# PORTLAND MAINE

June 30, 2009

RE: 8 Ryefield Street, Peaks Island – 084 E005 – IR-2 – porch steps – permit #08-1580

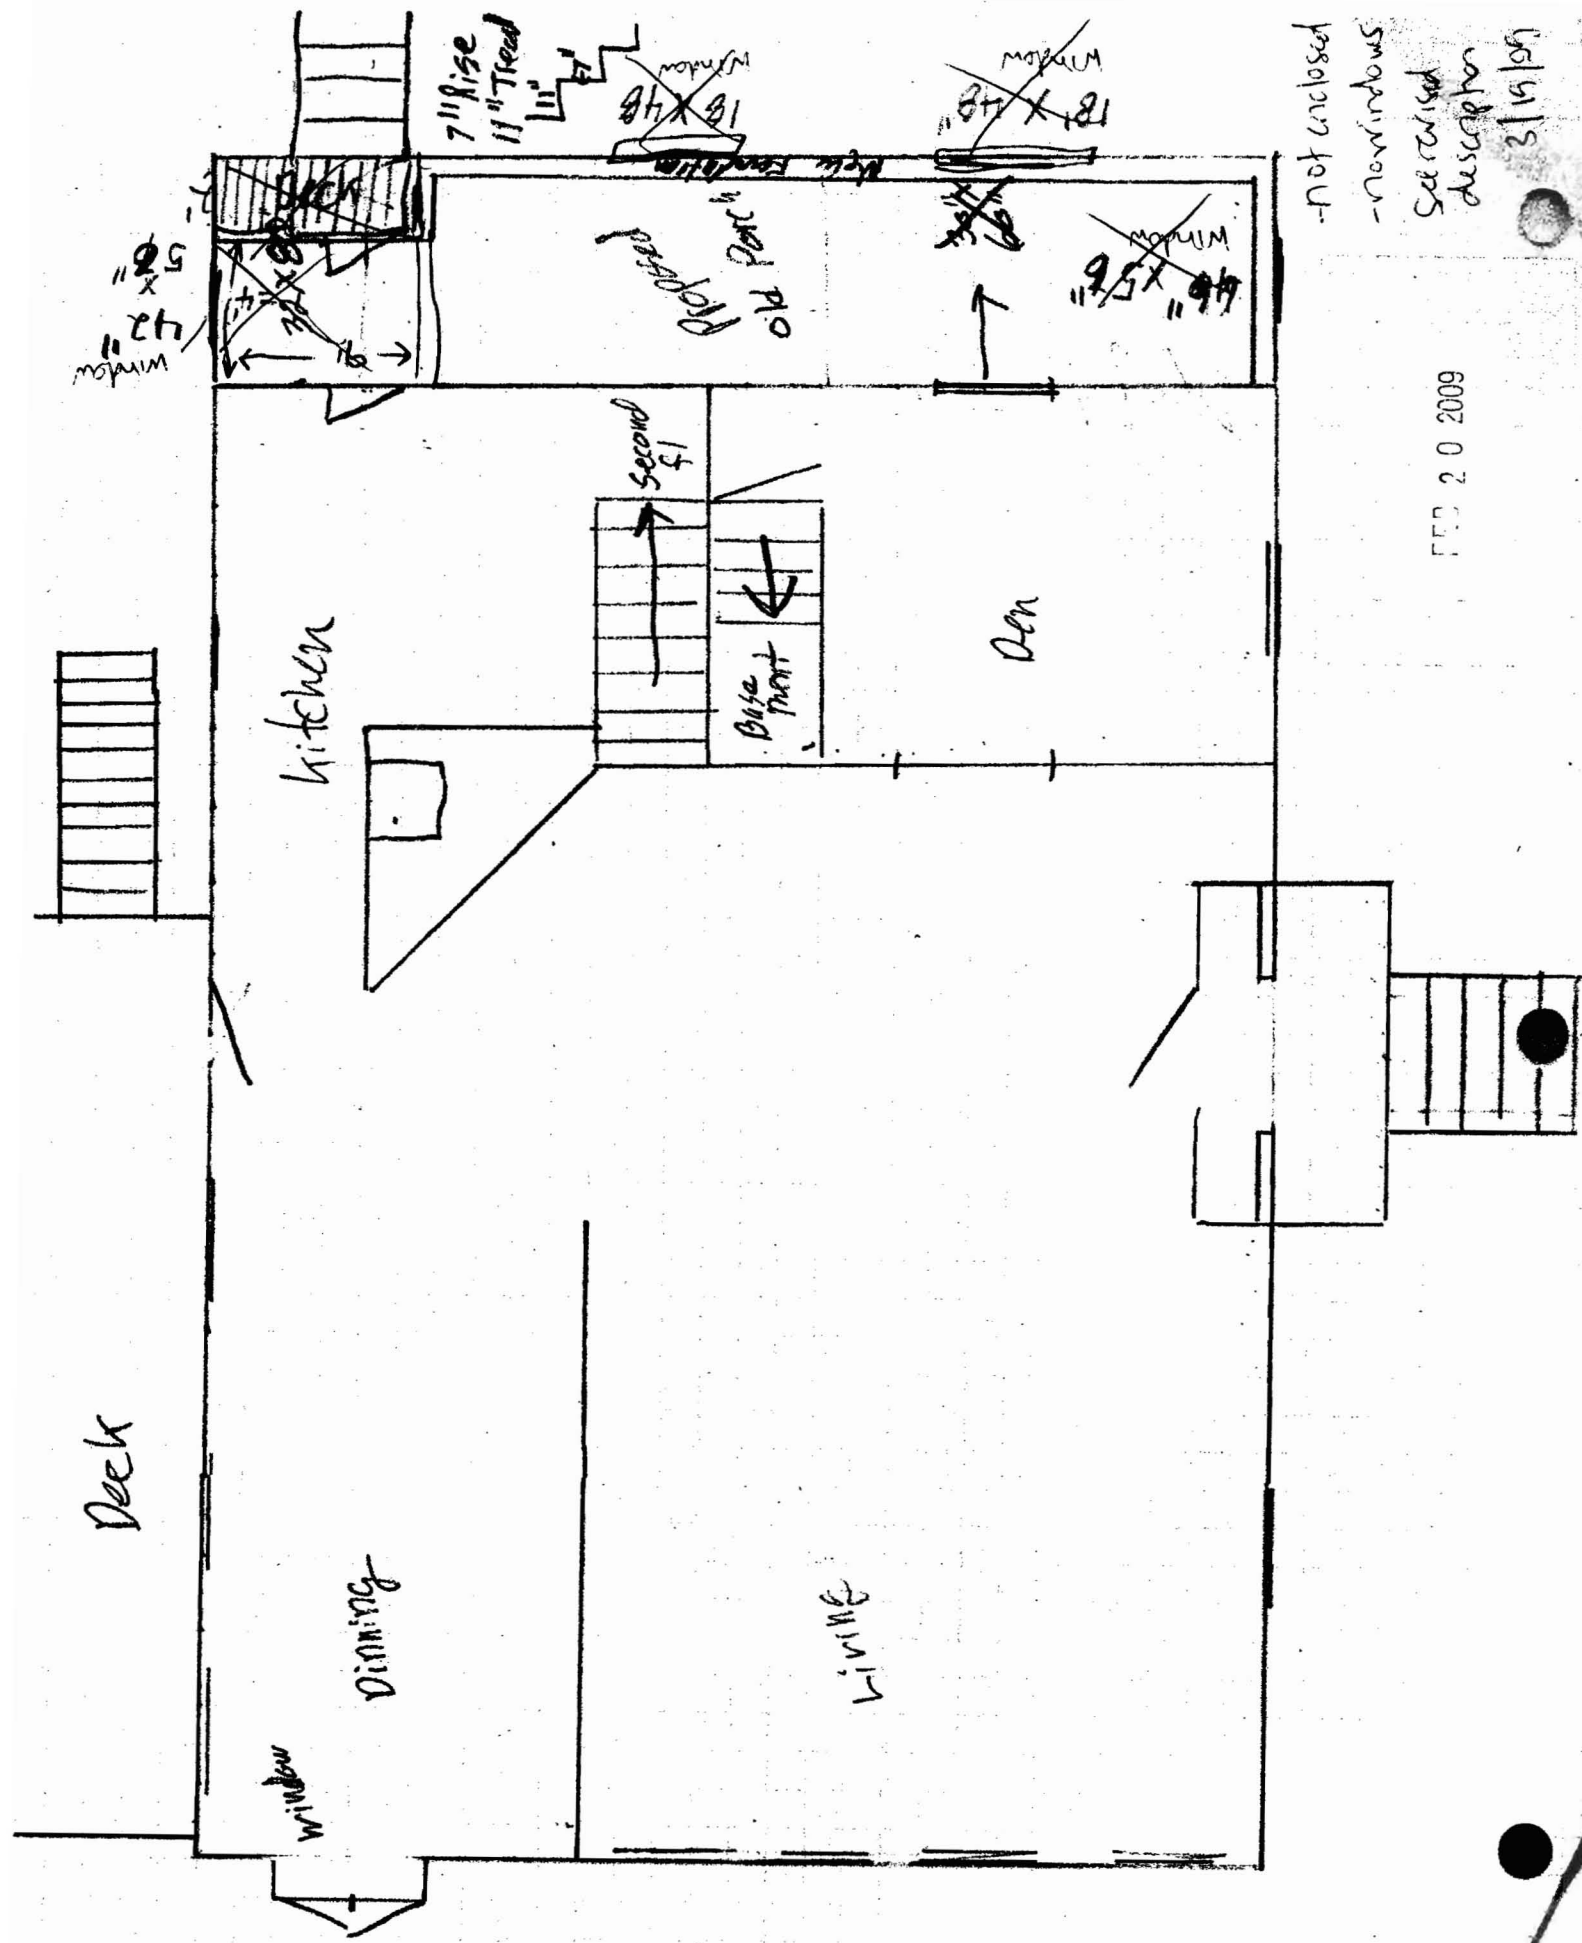
On May 10, 2009, I received a phone call from your neighbor Cynthia Mollus at 14 Ryefield Street. She was concerned that the stairs off the porch that is being rebuilt encroach on her property. I called her back on May 11, 2009 to talk about her concerns. I looked at the permit that had been issued, and the stairs off the porch were not shown on the plot plan. They were shown on the building plans but not on the plot plan, so I did not catch this in my review. We cannot issue a permit where the structure extends off the applicant's property. Since the porch itself extends right to the side property line, the stairs cannot be built off the side over the property line.

I called Terry Edwards immediately and told him that the stairs could not be built off the side of the porch. He said that he would contact you. He also said that he would relocate the stairs and submit a new plan to show where the stairs would go. I have not received an amended plan that shows where the stairs are being relocated. An amended plan needs to be submitted as soon as possible, and the stairs must be built accordingly once the new plan is approved.
